Application No: FG/29/22/HH
Site Address: 14 Ocean Drive Ferring BN12 5QJ
Description of works: Part two storey part single storey rear extension.

Thank you for your internet representation made on 12th April 2022 which has been recorded as an objection with the comments as follows:

Proposed First Floor Plan

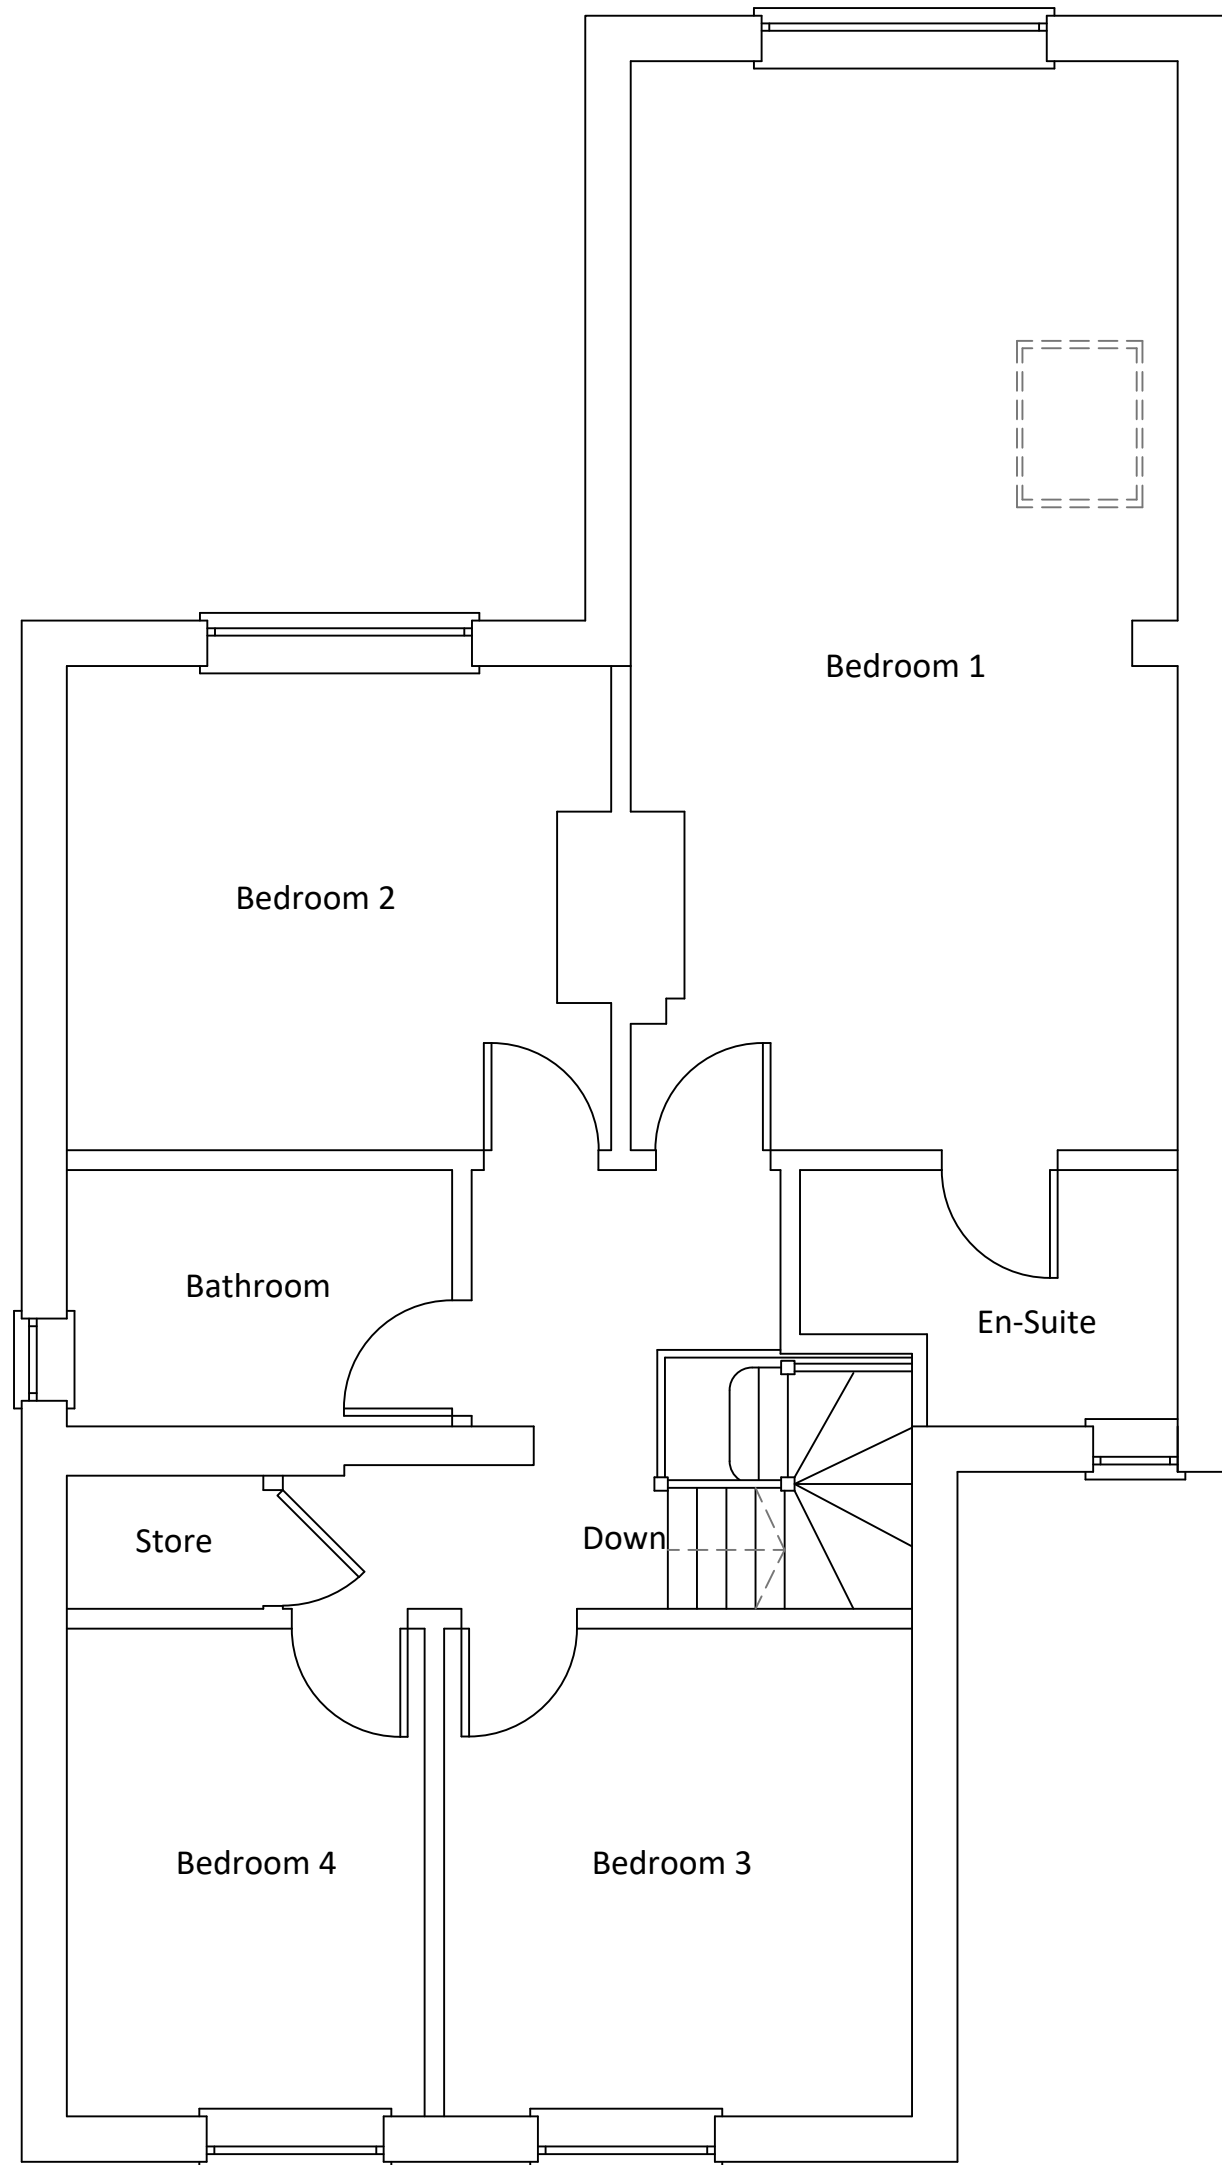
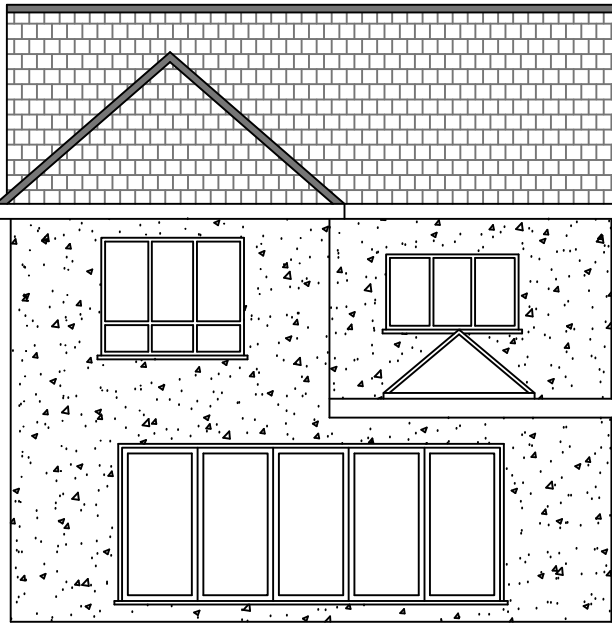
We wish to object to the above planning application on the basis that the proposed two story first floor element would be unacceptable as it would clearly invade our privacy even further than the existing first floor. Also this proposed planning application would over double the original building foot print.
